Planning Application Ref: M/17/20/T

Location: Builders Yard, 17 Harefield Road, Ancton, Middleton-On-Sea, PO22 6EE

Description of works: Crown lift to approx. 6m, reduce back to first leader lowest limb to south over entrance drive, reduce mid crown back by 3m, upper crown by 2.5m and height by 2m to 1no. sycamore tree

TREE LOCATION PLAN

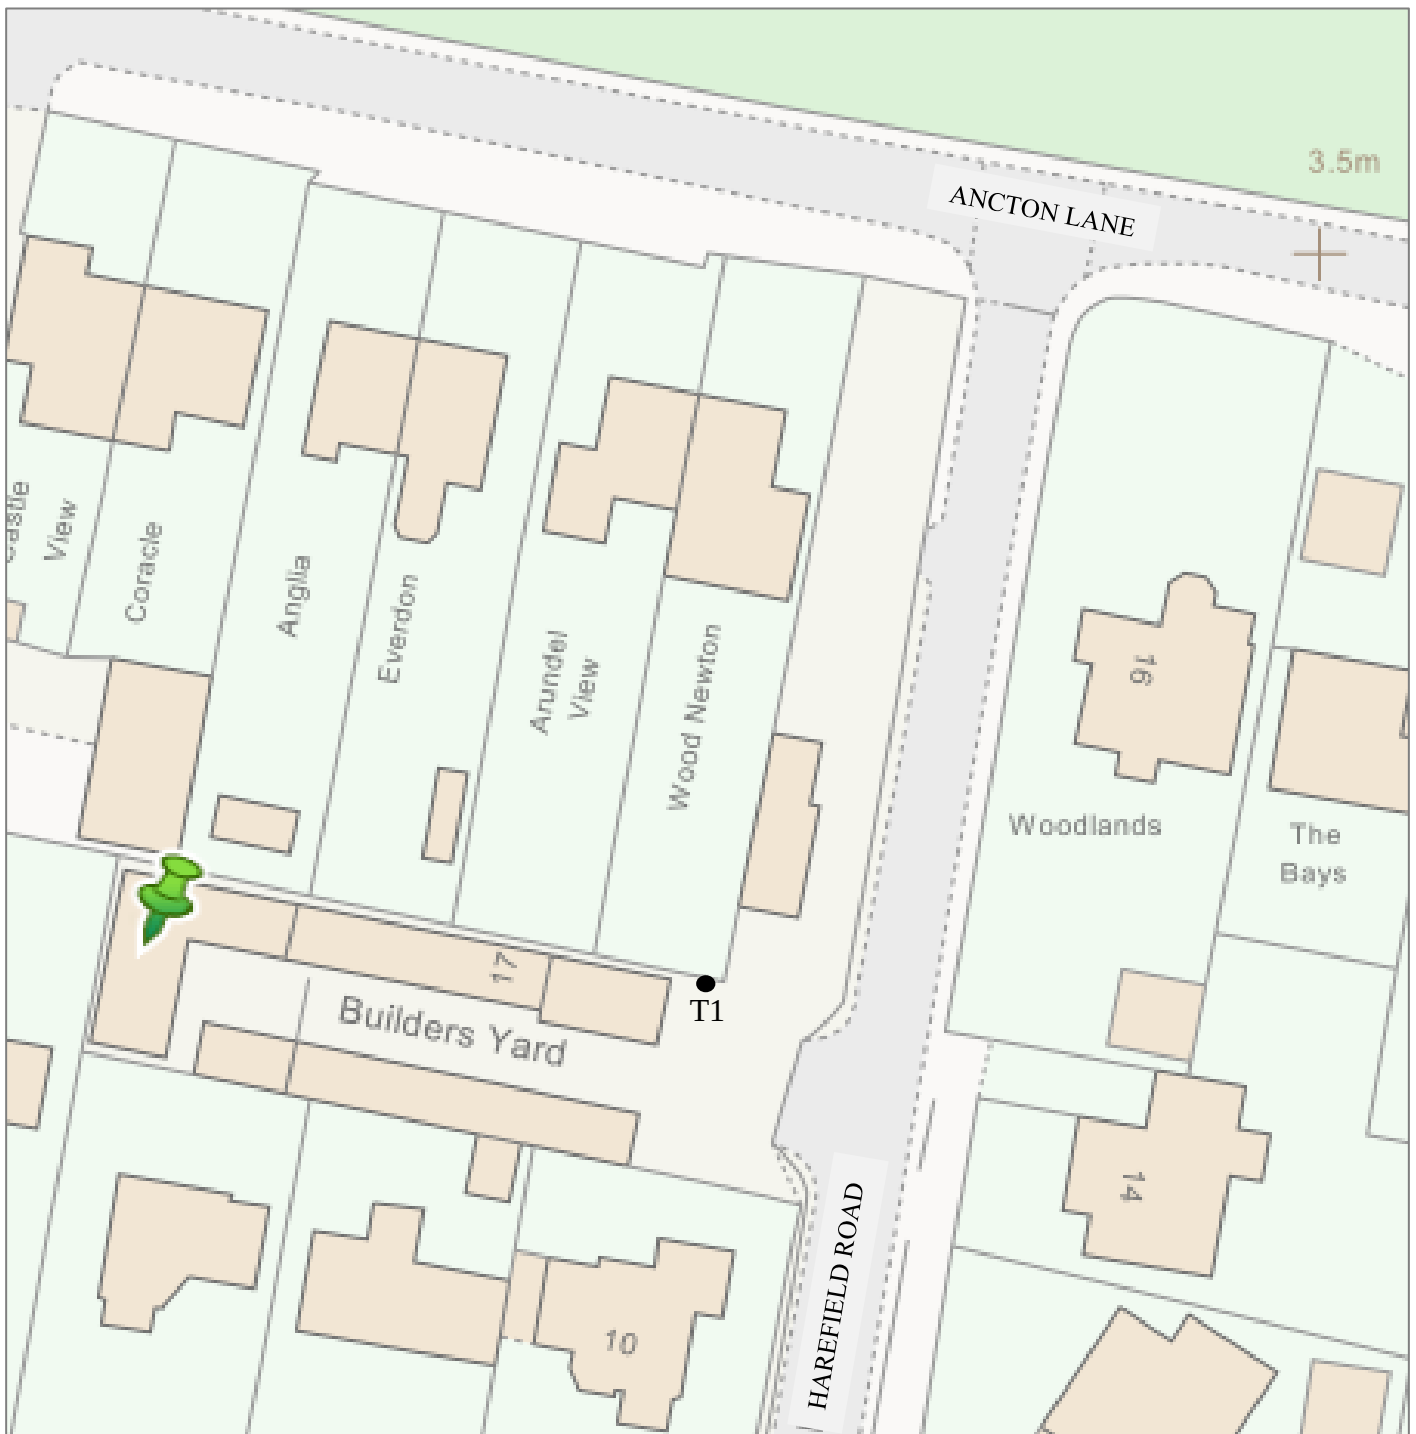
- This tree appears to be in fair physiological condition and stable, with a relatively unmodified and attractive upper crown profile. Stem compression is a concern when viewed from the south although no evidence to suggest this is a defect with significant implications at this time.
- This is a landmark tree; visible from numerous properties and to traffic (vehicular and pedestrian) accessing/exiting from this side of the estate as well as the public highway. It is clearly a tree of high amenity value.
- Overhead clearance appears adequate (c4metres all aspects) although some low branches could be removed/reduced to ensure longer-term clearance for high-sided vehicle access.

- This tree requires careful management that respects its age and vulnerability to environmental changes and disease progression.
- The removal of low branches to achieve 6m clearance above ground level (on all aspects) is not justified on arboricultural grounds and exceeds that which is recommended in the British Standard (BS3998:2010) Tree work – Recommendations.
- The tree is a significant feature in the local landscape and appears to be in adequately sound and healthy condition. The tree surgery proposed in the application would result in excessive reduction of the tree's landscape impact and undue detriment to the visual amenities of the locality.

- As it stands, I recommend **REFUSAL** for this application.

- I would like to see the applicant submit a revised work specification such as detailed below, which would seem to address their primary concern whilst preventing a diminution of the tree's landscape and public amenity value:
 - Crown lift on south aspect and immediately above hard standing/driveway only, to achieve a maximum of 5.5metres overhead clearance.

- Part a) Where whole branches are to be removed and final cuts made close to the trunk or branch union they are to be made as shown in Figure 2 of BS3998:2010
- Part b) Where branches are to be shortened back the final cuts are to be made at the correct angle shown in BS3998:2010 and adjacent to a live bud or lateral.
